Our reference: ECM: 8369733
Contact: Kathryn Sprang
Telephone: 4732 7834

19 September 2018

Altis Warehouse and Logistics Hub at Nos. 585-649 Mamre Road, Orchard Hills (SSD 7173 MOD 4)

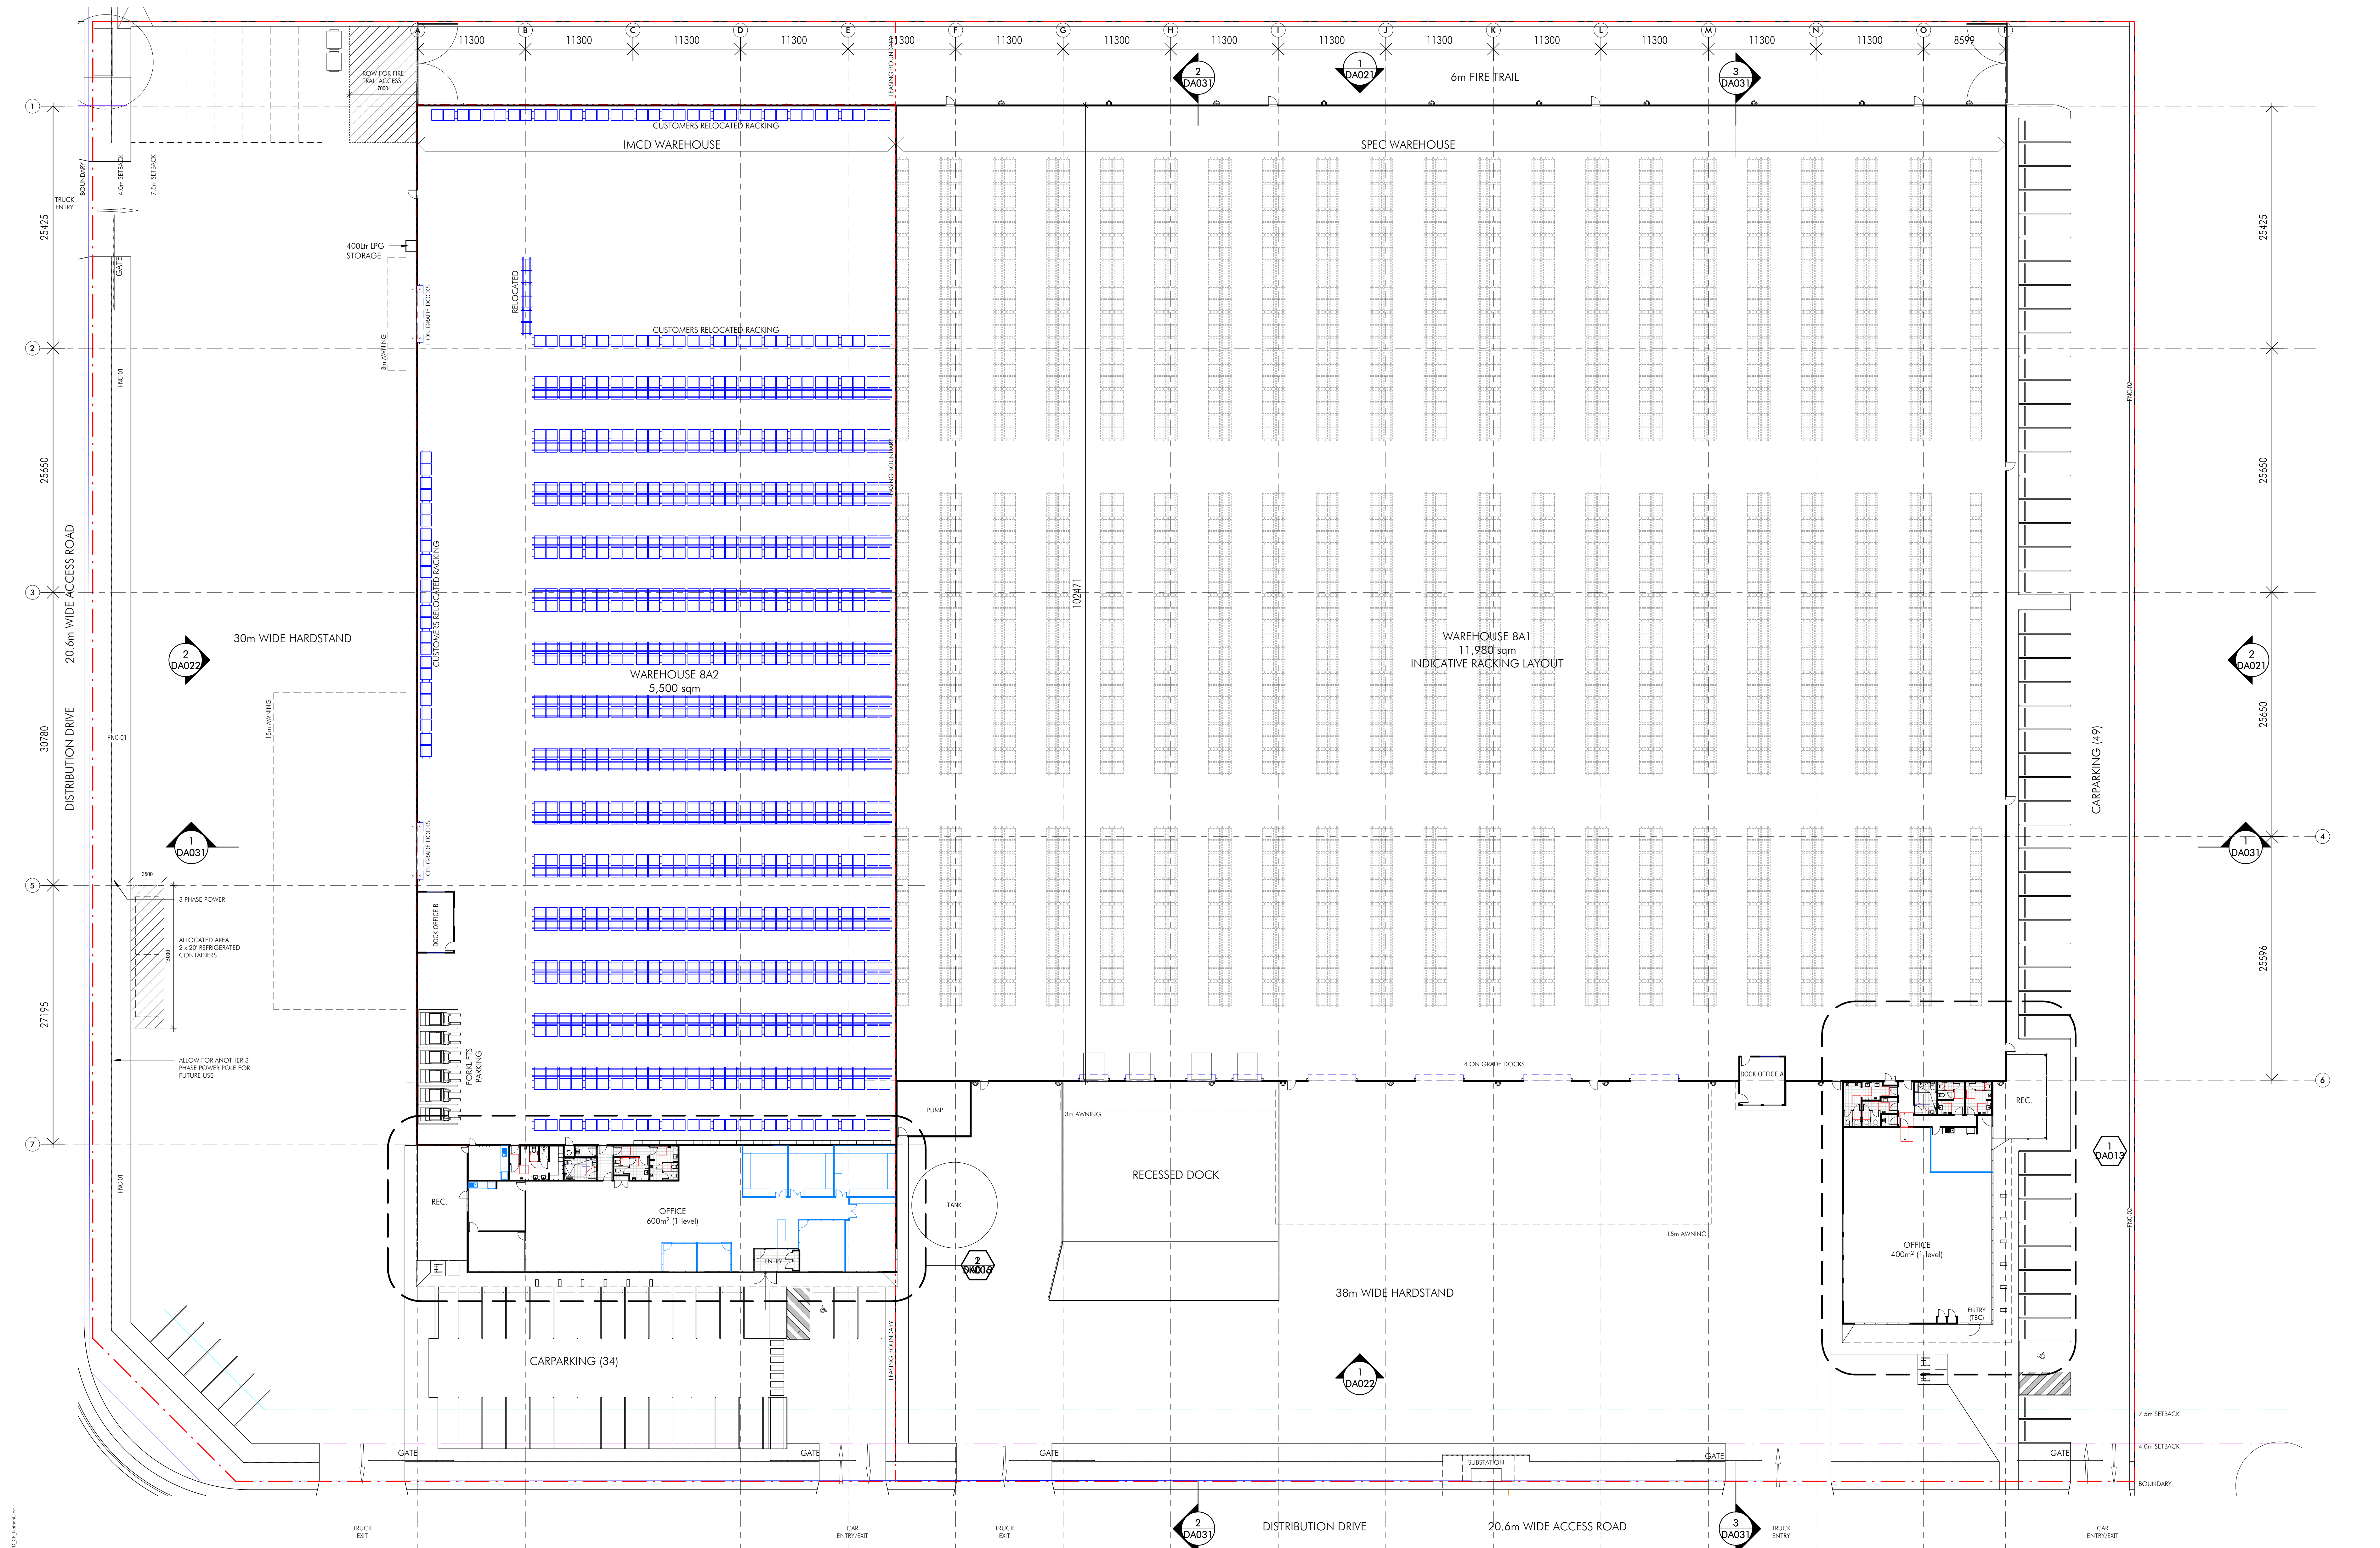
The proposed building footprint and siting is significantly different from what was previously approved. The modification application proposes loading docks on both street frontages, which are highly visible from the public domain and are contrary to the Mamre West Land Investigation Area Development Control Plan(DCP) (see section 3.3.3 Materials and Finishes) and Penrith City Council's DCP control (see DCP 2014 part E6 Erskine Business Park – 6.3.4 Urban Design). The plans that were previously approved concealed the loading dock from the public domain. This is critical to ensure that servicing for the development does not dominate the streetscape. As such the proposed building configuration and access arrangements are not supported and reinstatement of the approved loading dock location as previously approved is requested..

It is also noted that on the South- Western elevation (fronting Distribution Drive) there are refrigerated containers, and 40 containers on the south- western corner of the site. These containers are located/partially located within the front setback and as such do not present a desirable interface with the public domain. The location of these containers should be moved within the building or located internally within the site and screened from view of the street.
